Submission Form

Epping to Thornleigh Third Track Proposal. Application number SSI 5132.

Name(s): CAROLYN BETTY MALLAMAddress: 16 THE PROMENADE CHELTENHAM 2119*strongly*

Figure 5.6 Cross-section and elevation - New Cheltenham Station concourse building
Note: Indicatively added to future design

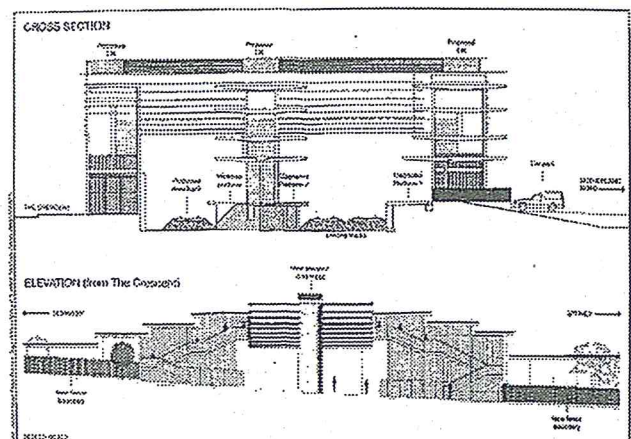
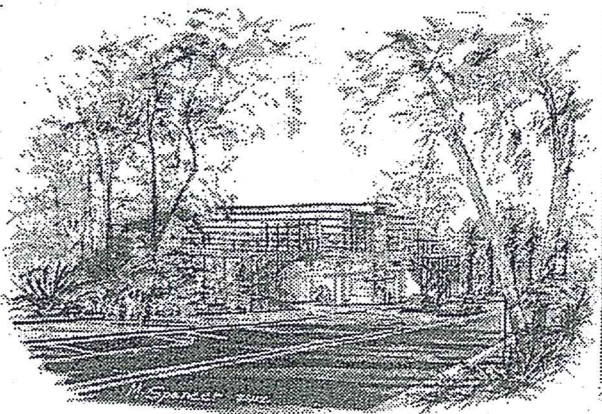
- The proposed redevelopment of Cheltenham Station shows no regard for the HCA. The visual impact of the proposed 13m high glass and steel concourse is totally unacceptable in this HCA. *The present station at Cheltenham is ideally suited for commuters. The changes will make it more unsuitable.*
